STATE OF NORTH CAROLINA
DEPARTMENT OF TRANSPORTATION

Addendum No. 1

RE: Contract ID C203703
WBS # 8CR.10531.27, Etc.

US-1 From NC-42 To North Of US-421, NC-87 From SR-1290 To
Harnett County And 3 Sections Of Secondary Roads

TYPICAL SECTION NO. 1

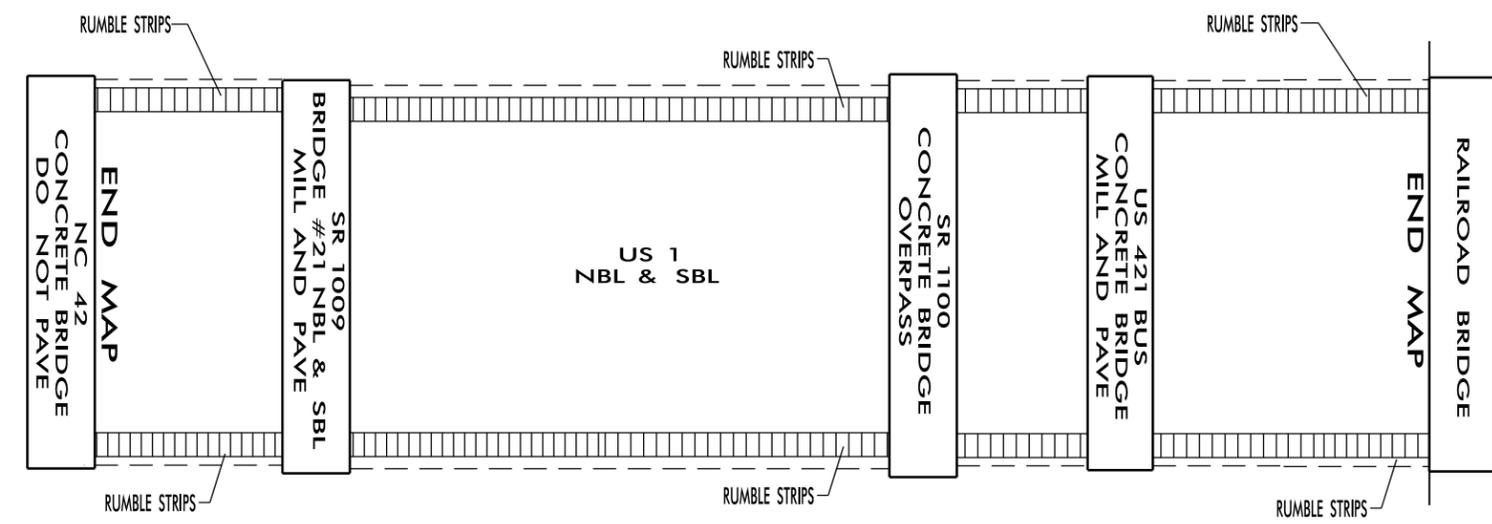
Sheet No.	Revisions
3	Revised Typical Section No. 1 to add milling of existing rumble strips
8	Revised "Summary of Quantities" to reflect the below noted quantity changes
